ATTACHMENT A

MPW Stage 2 – TfNSW Second Response

¹ Some other intersections impacted by the Moorebank Precinct are part of discussions between SIMTA, Transport for NSW and NSW Roads and Maritime Services, relating to an agreed mitigation framework for the MPE and MPW Projects.
MPW Stage 2 Proposal - SIMTA TfNSW 2nd Response

Intersection of Moorebank Avenue and Anzac Road
AM PEAK
Signals - Fixed Time Isolated

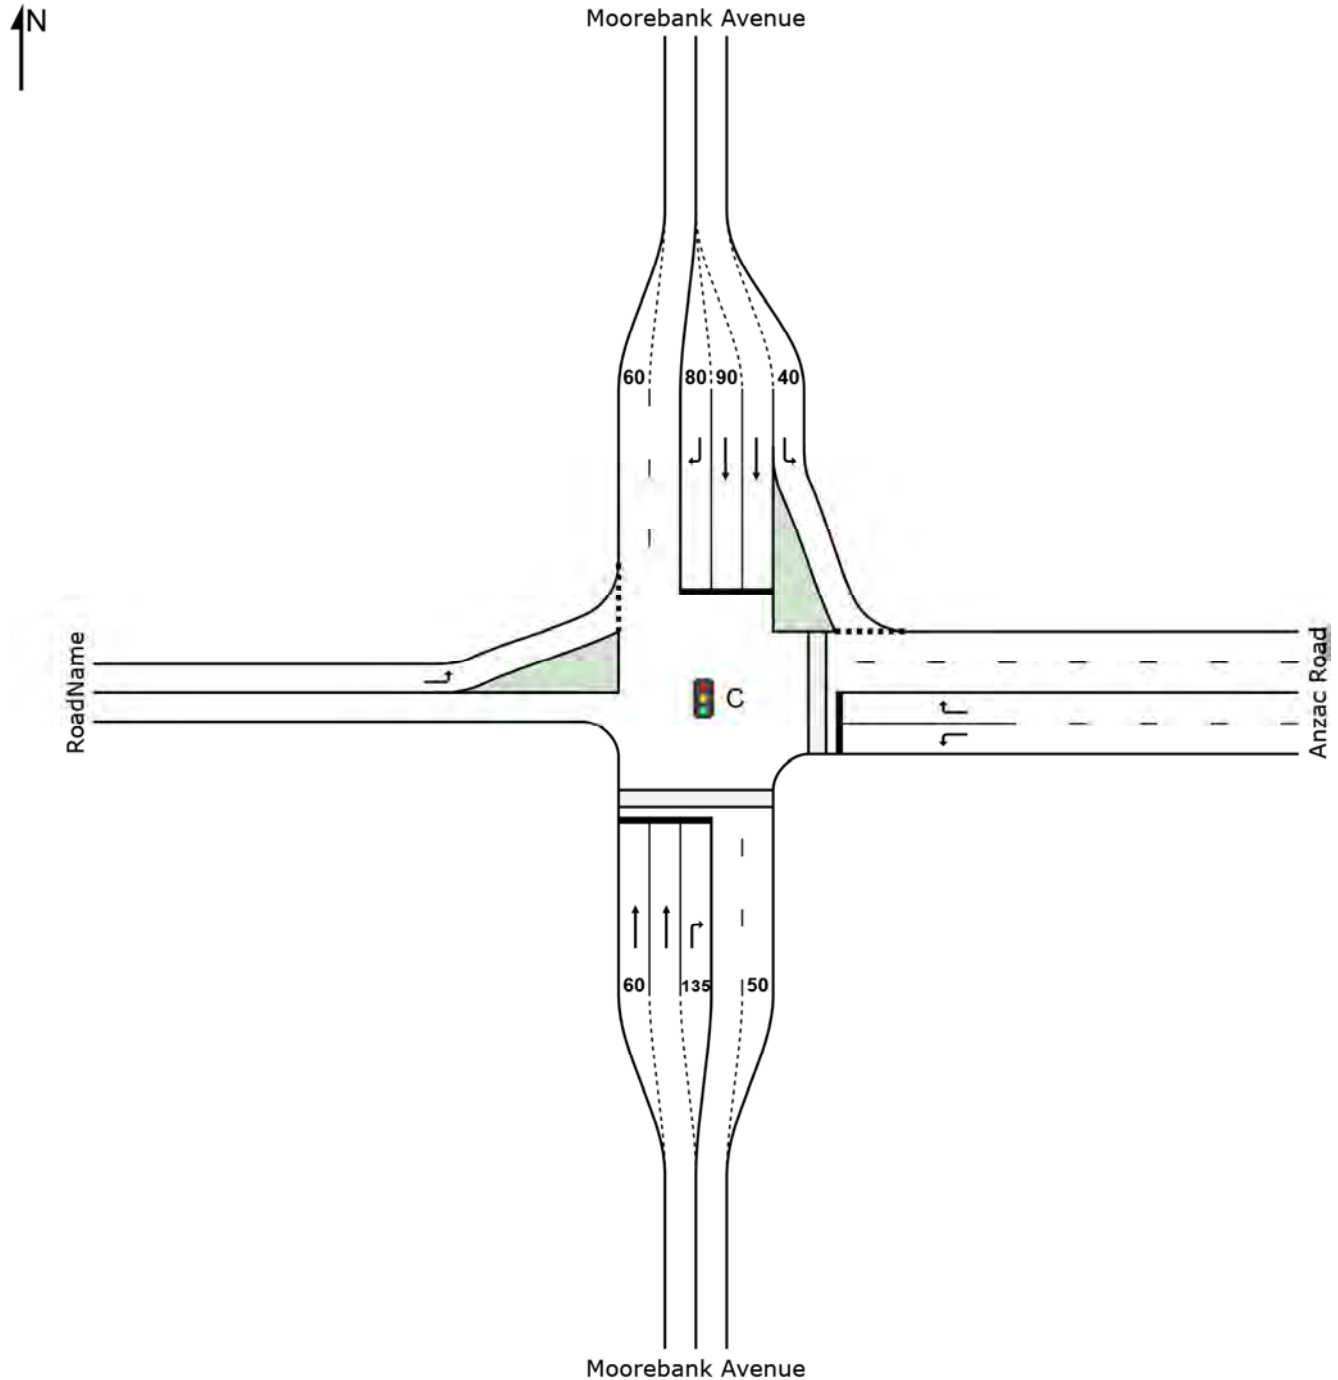
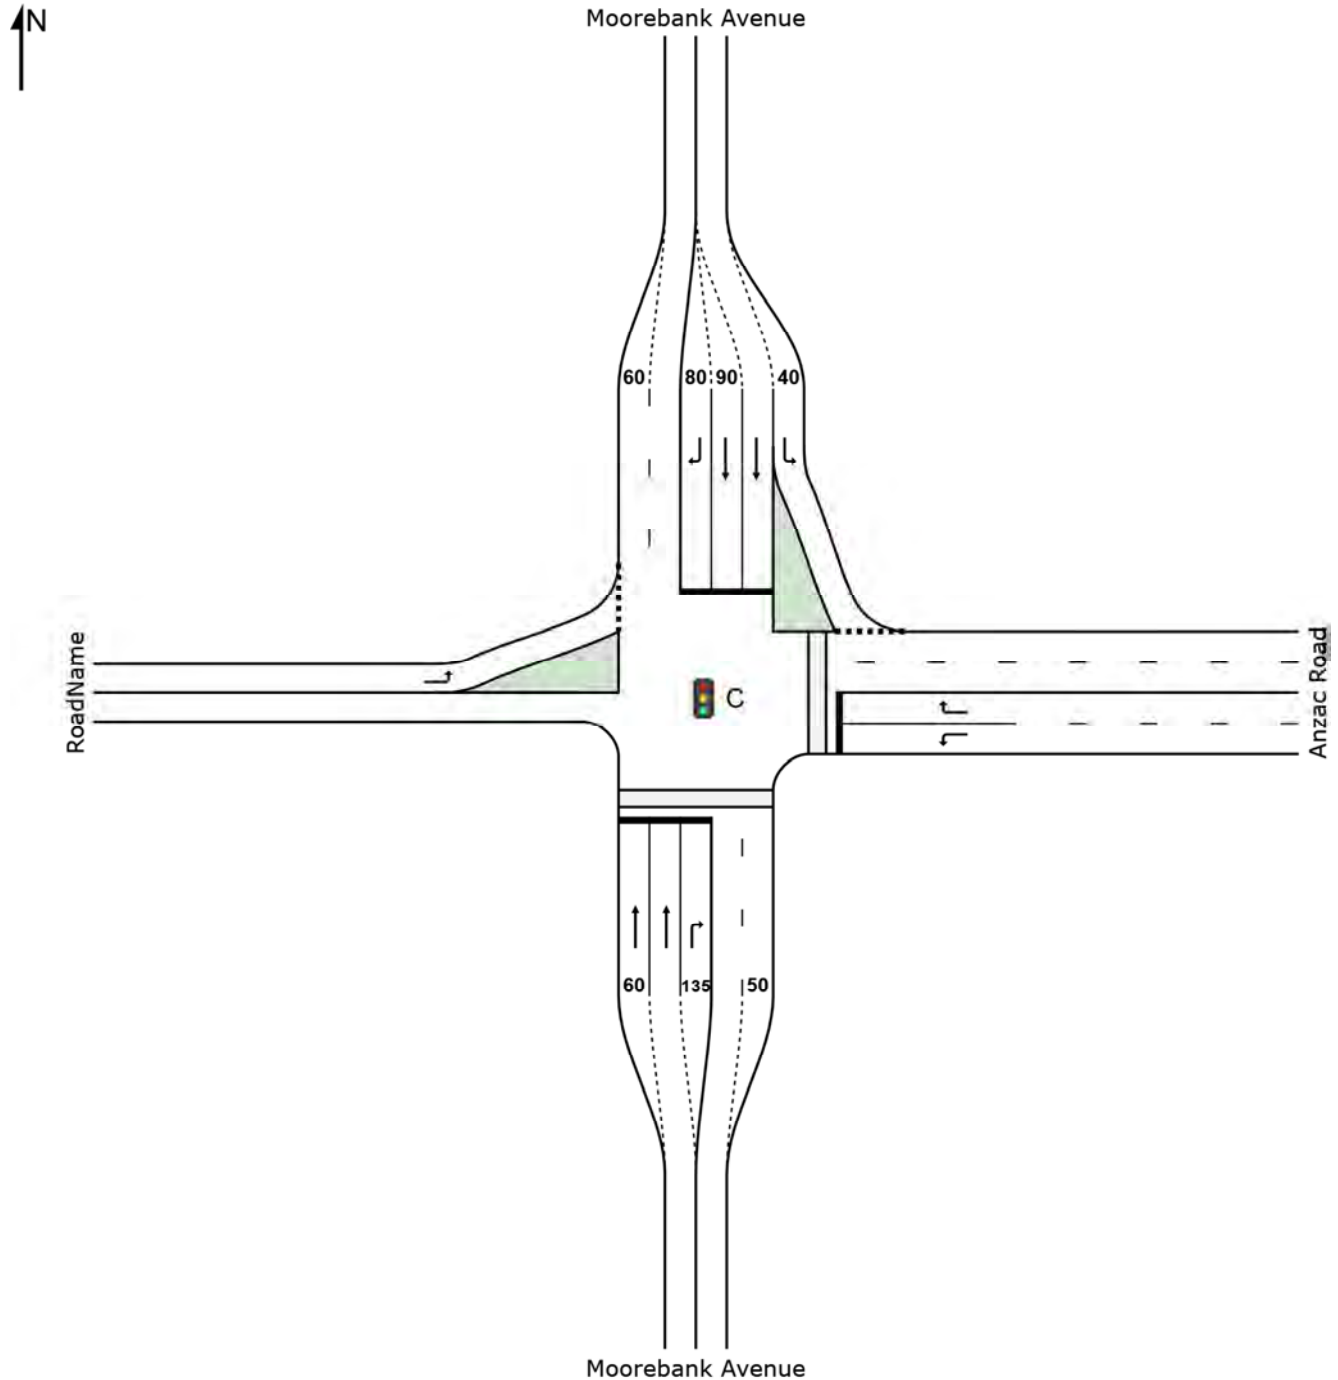
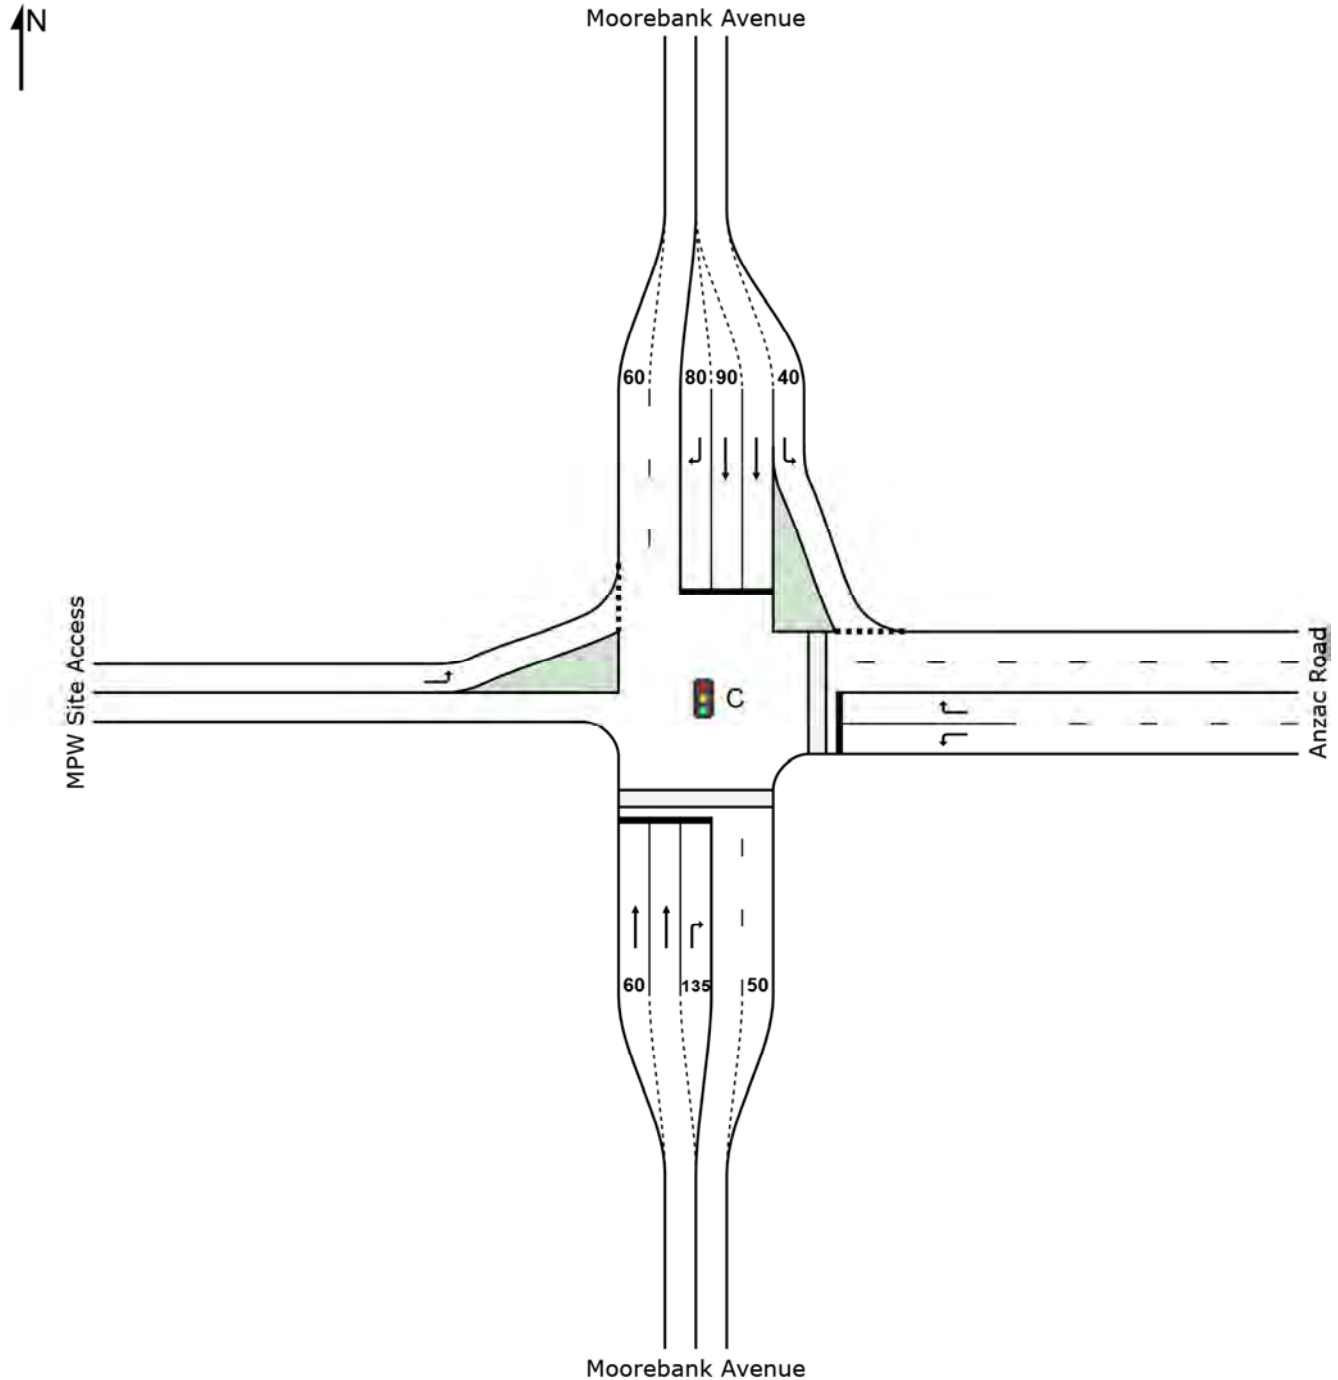
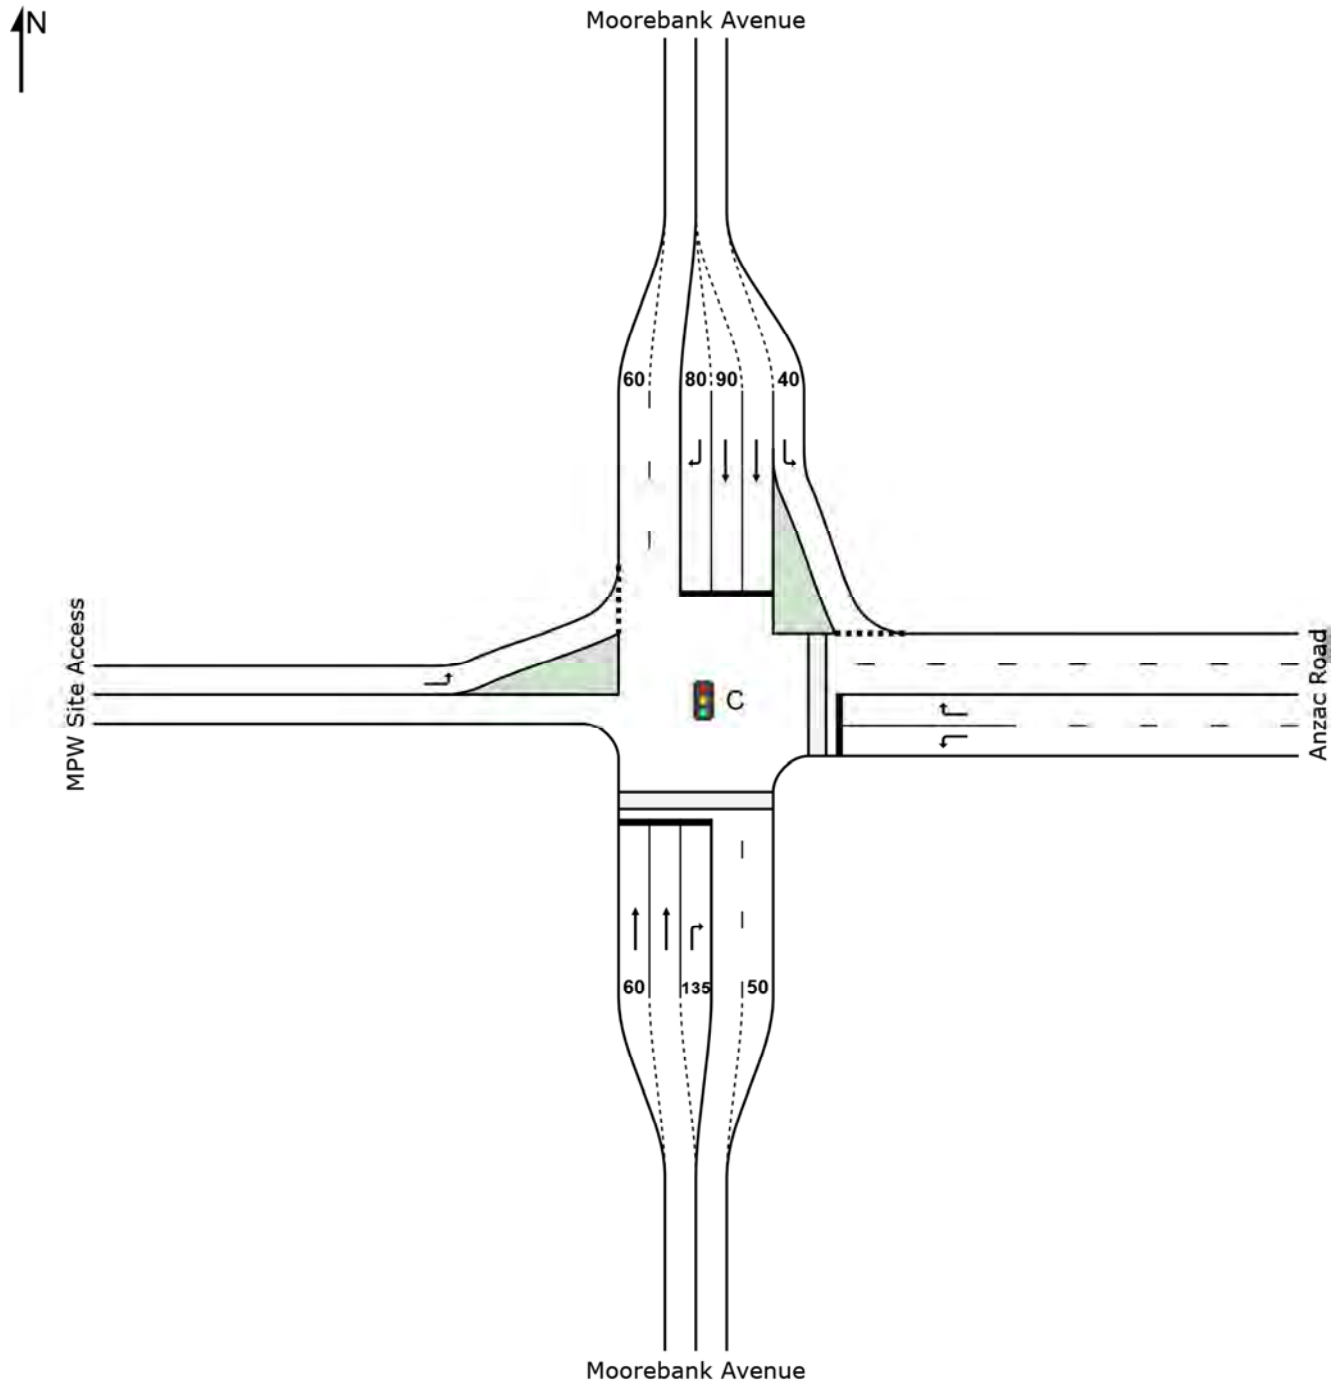
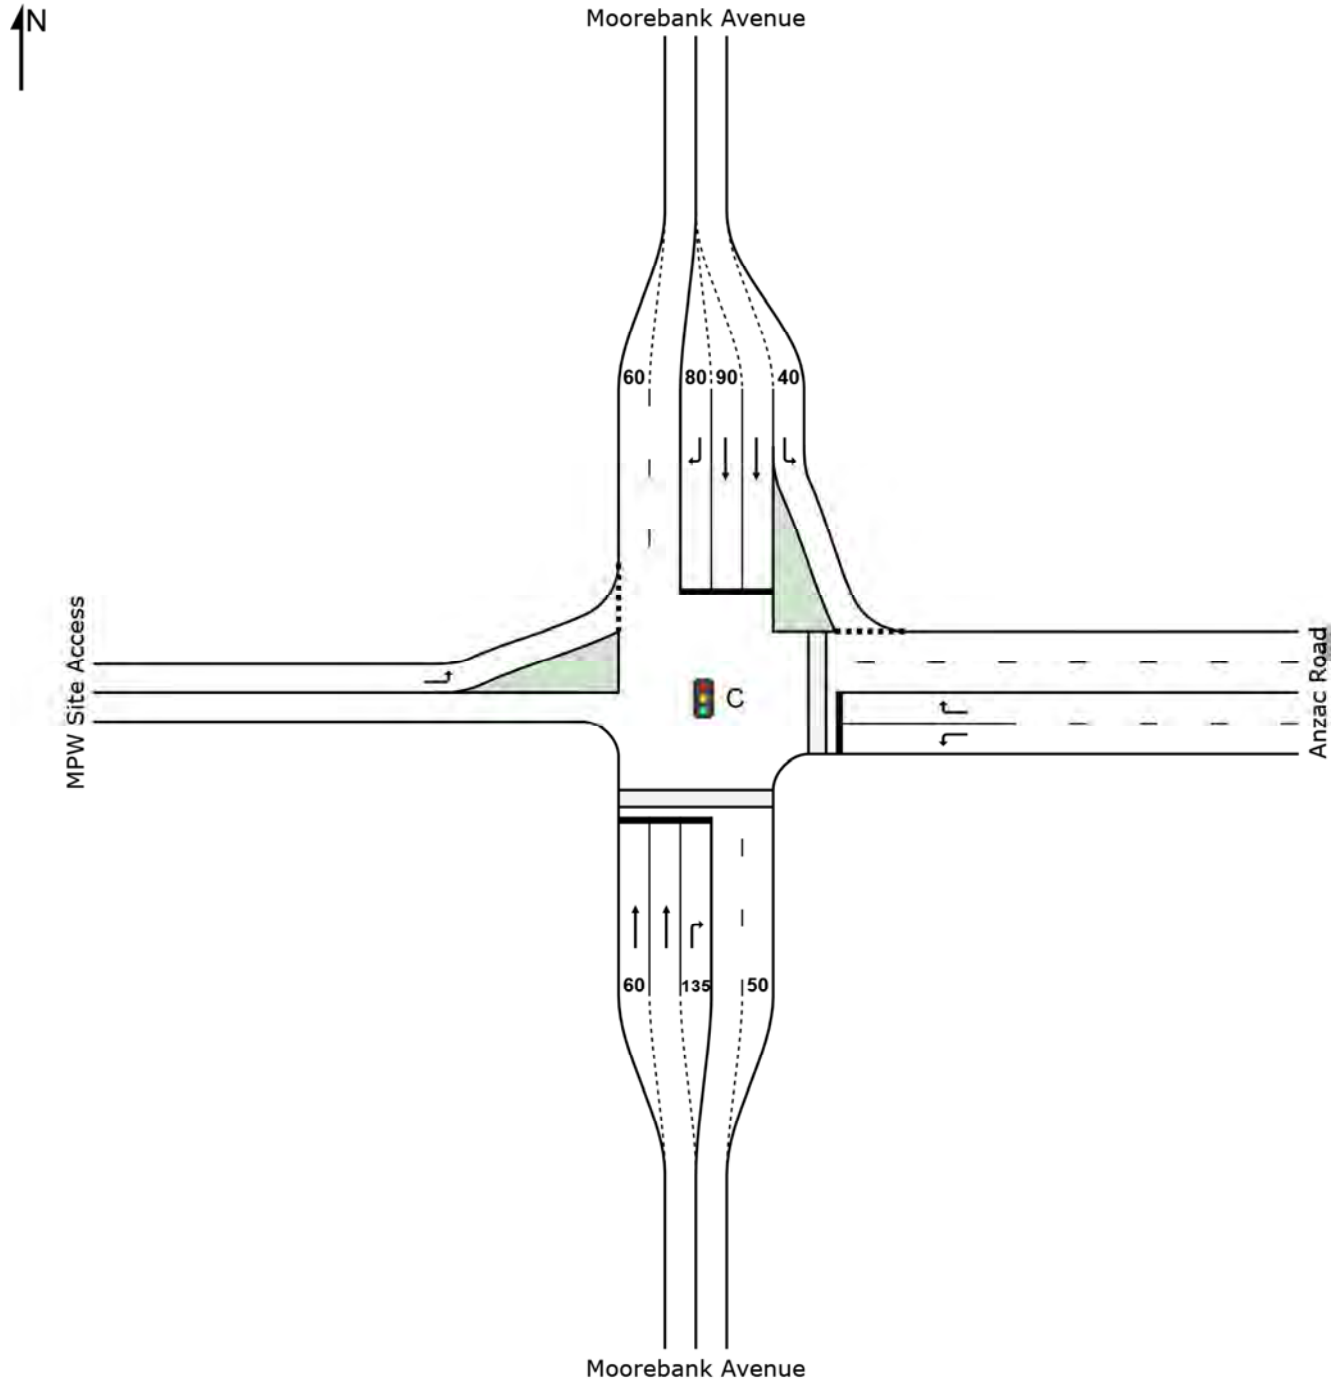
TfNSW Submission	SIMTA Response	Reference
	<ul style="list-style-type: none"> – One left turning slip lane onto Moorebank Avenue (southbound) • Moorebank Avenue (northbound): <ul style="list-style-type: none"> – Two right turning lanes onto Anzac Road (eastbound) – Two through lanes continuing on Moorebank Avenue (northbound) – One left turning slip lane onto the new access road (westbound). <p>The MPW Stage 2 Proposal also includes an associated upgrade to the Moorebank Avenue / Bapaume intersection with the final configuration to be the following:</p> <ul style="list-style-type: none"> • Moorebank Avenue would be reconfigured for no right turn onto Bapaume Road from Moorebank Avenue • Bapaume Road would be reconfigured for no right turn onto Moorebank Avenue from Bapaume Road • The reconfigured Bapaume Road would allow the following movements: <ul style="list-style-type: none"> – Inbound traffic to the ABB site would be directed to the new Moorebank Avenue/Anzac Road intersection (main MPW site entrance) – Northbound traffic out of the ABB site would use Bapaume Road or the new Moorebank Avenue/Anzac Road intersection (main MPW site entrance) – Southbound traffic out of the ABB site would use the new Moorebank Avenue/Anzac Road intersection (main MPW site entrance). <p>Additional intersections within the broader network, as identified in the Operational Traffic and Transport Impact Assessment (Appendix M of the EIS), also require improvements by Roads and Maritime to accommodate background growth. These intersections¹ include:</p> <ul style="list-style-type: none"> • M5 Motorway/Hume Highway • Moorebank Avenue/Newbridge Road • Moorebank Avenue/Heathcote Road • M5 Motorway/Heathcote Road.

TfNSW Submission	SIMTA Response	Reference
	<p>Recommended improvements to these intersections are suggested, however, as the Proposal does not worsen intersection performance, these improvements are not included as mitigation measures for the Proposal (refer to Appendix M of the EIS and Appendix C of the RtS).</p> <p>Overall, the upgrade of the Moorebank Avenue / Anzac Road intersection and the associated road network improvements to be undertaken by Roads and Maritime would result in an improvement to the road network during the operation of the MPW Stage 2 Proposal. In consideration of this, the MPW Stage 2 Proposal is, subject to the implementation of upgrades, not considered to exceed the capacity of the road network and is therefore consistent with the MPW Concept Approval.</p> <p>Further, Section 5.4.1 of the MPW Stage 2 EIS provided an assessment of the Proposal in consideration of the requirements of the <i>Liverpool Local Environmental Plan 2008</i> (Liverpool LEP 2008). In particular, this assessment considered the requirements of clause 7.36 of the Liverpool LEP 2008. In summary, the MPW Stage 2 Proposal complies with clause 7.36 of the Liverpool LEP 2008 in that it proposes an intermodal terminal, warehousing, rail connection and conservation area on areas shown in the Key site map (associated with this clause) and that the Proposal includes the provision of upgrades to the Moorebank Avenue/Anzac Road intersection.</p>
